August 24, 2022

Kelly Bacon, Kittitas County Planner I
Community Development Services
411 N. Ruby Street
Ellensburg, WA. 98926

The following comments are the Environmental Public Health comments on the CU-15-00002, Yakima River Campground project application as well as the SP-15-00001. The applicant must work with the Washington State Department of Health (WSDOH) to re-activate the original Group A-Transient Non-Community water system that is on the property or arrange with the Kittitas County Public Health Department to perform a well site inspection to approve the location of a new public water source to serve the project. If the original system is reactivated, the applicant must work on a water system plan with the WSDOH as the next phase of the project will increase the use of the existing water system that was once approved.

YAKIMA RIVER SHORT PLAT - SP 15-XXXXX
 A PORTION OF THE NORTH 1/2 OF SECTION 4,
 TOWNSHIP 19 NORTH, RANGE 16 EAST, W.M.,
 KITTITAS COUNTY, WASHINGTON

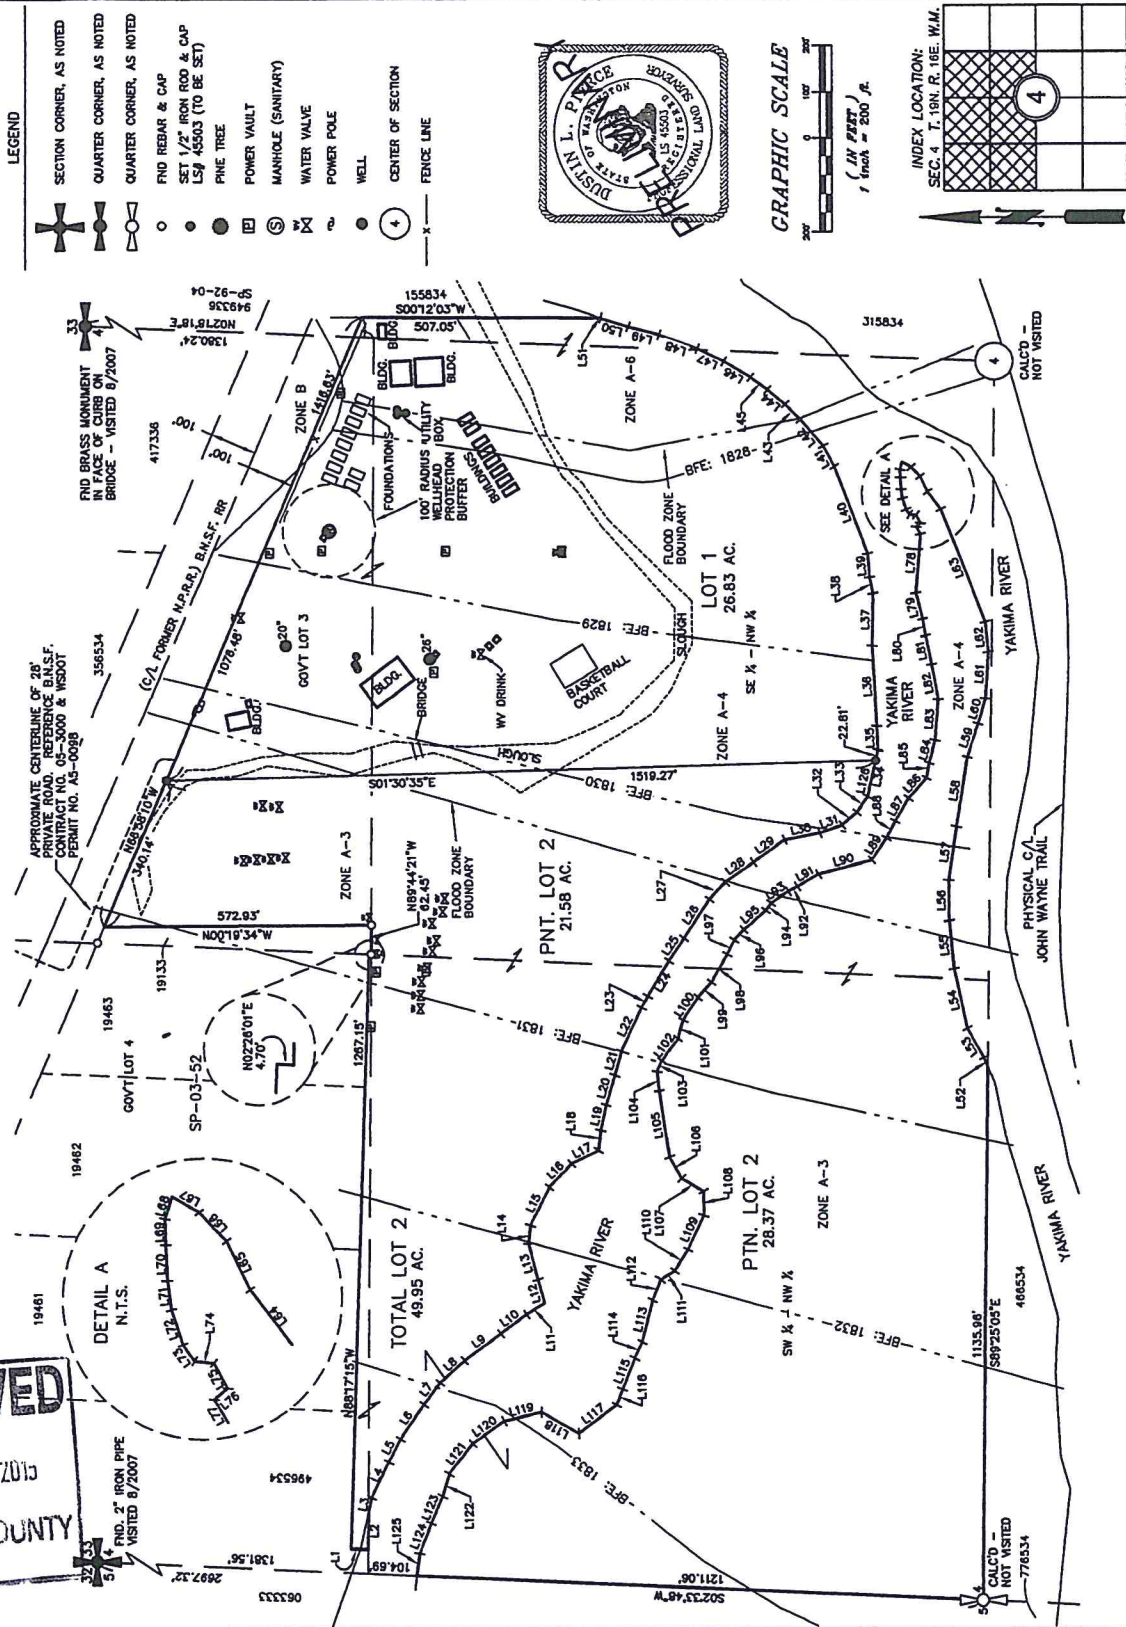
Regarding the proposed 2 lot short plat, there is an existing well and drainfields located on parcel 19-16-04020-0002. No soil log or well is required for that proposed lot. Parcel 19-16-04050-0401, is 0.60 acres and is not large enough to have an on-site sewage system and a well located on it.
